Addendum No. 3

RE: Contract # C204359

US-70 FROM US-70 BUS TO NEUSE RIVER BRIDGE WITH INTERCHANGES
AT SR-1501 (SWIFT CREEK RD) AND SR-1919 (WILSONS MILLS RD).

The following revisions have been made to the Roadway plans.

SHEET NO.
2A-2

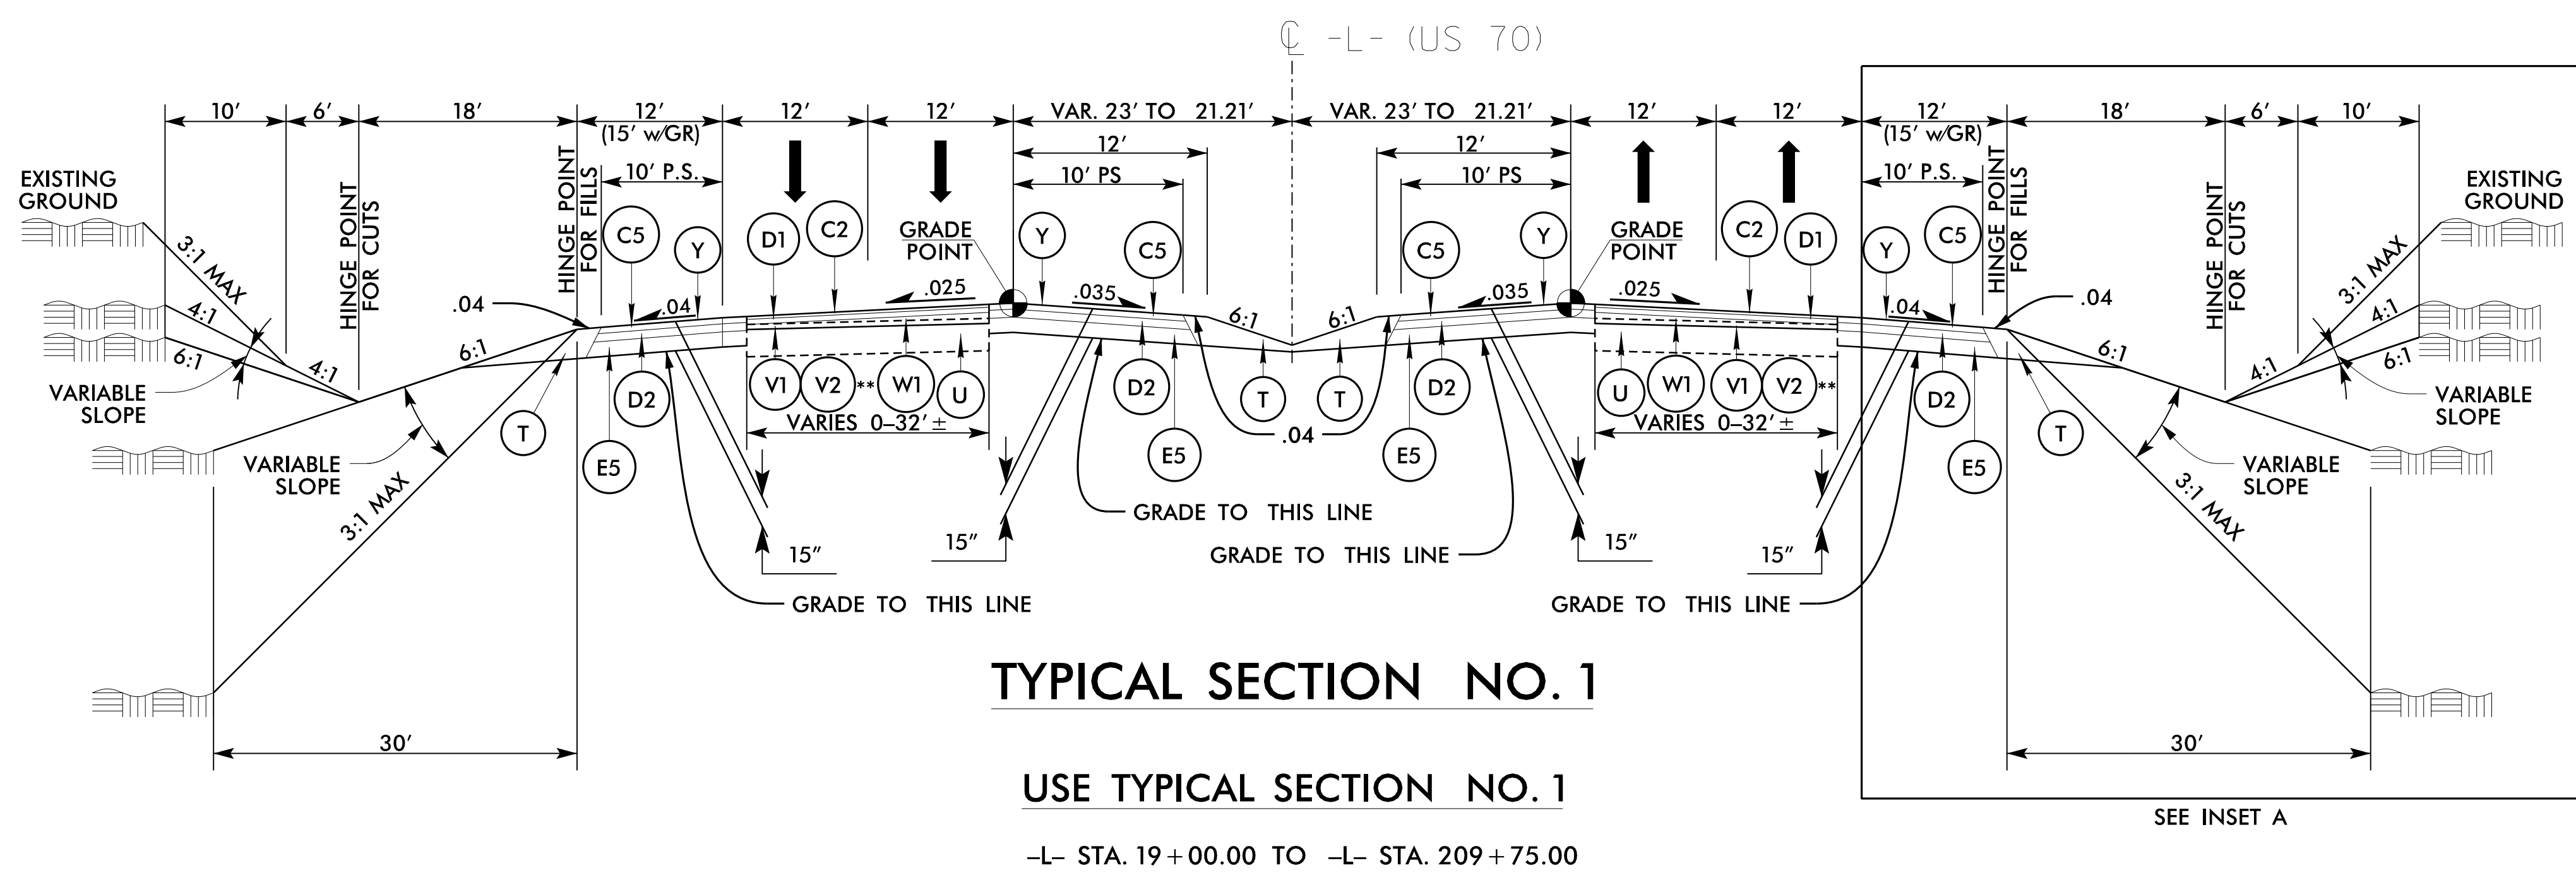
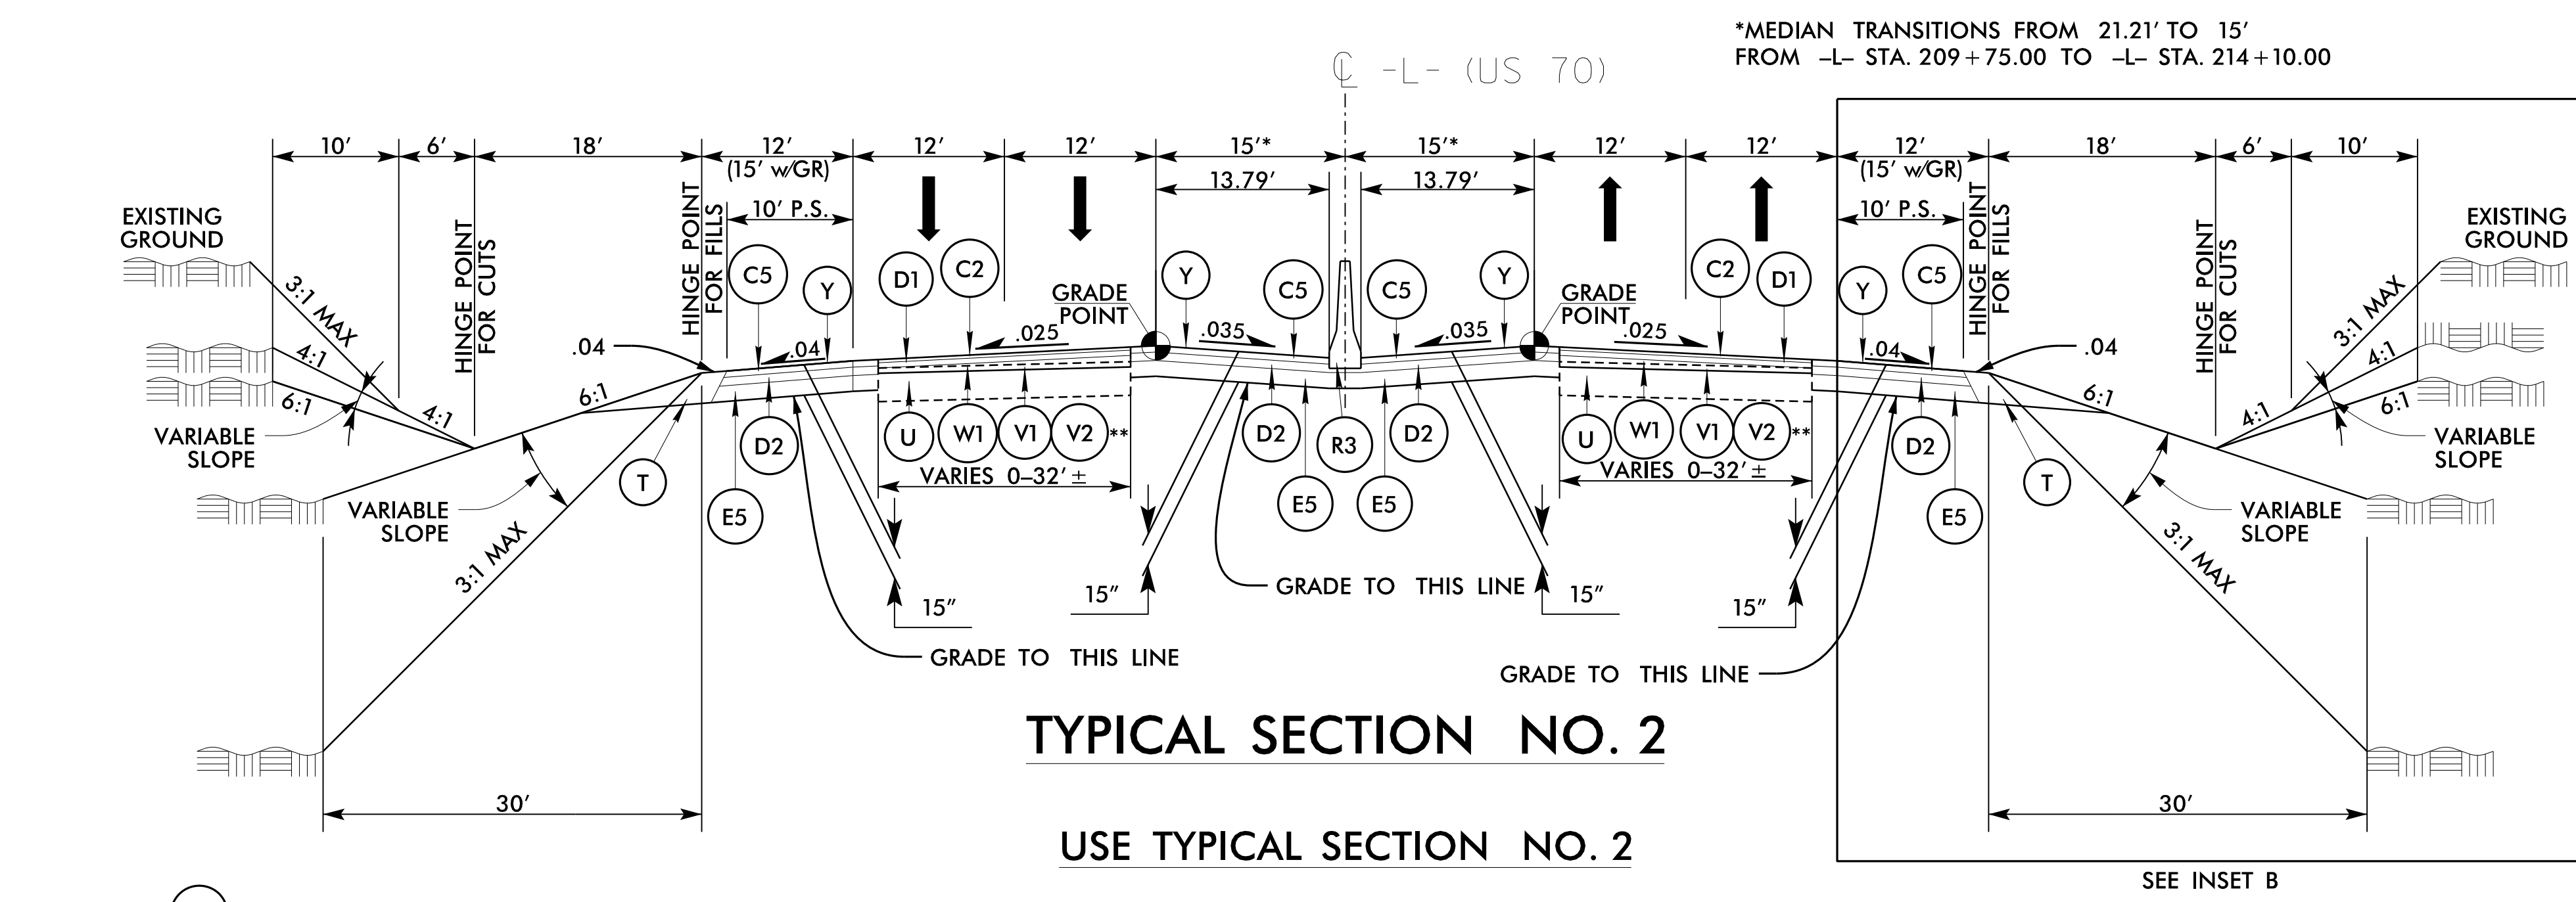
Sheet No.	Revision
2A-1	Revised typical sections to reflect quantity changes listed below
2A-2	Revised typical sections to reflect quantity changes listed below
2A-3	Revised typical sections to reflect quantity changes listed below
2A-4	Revised typical sections to reflect quantity changes listed below
2A-5	Revised typical sections to reflect quantity changes listed below
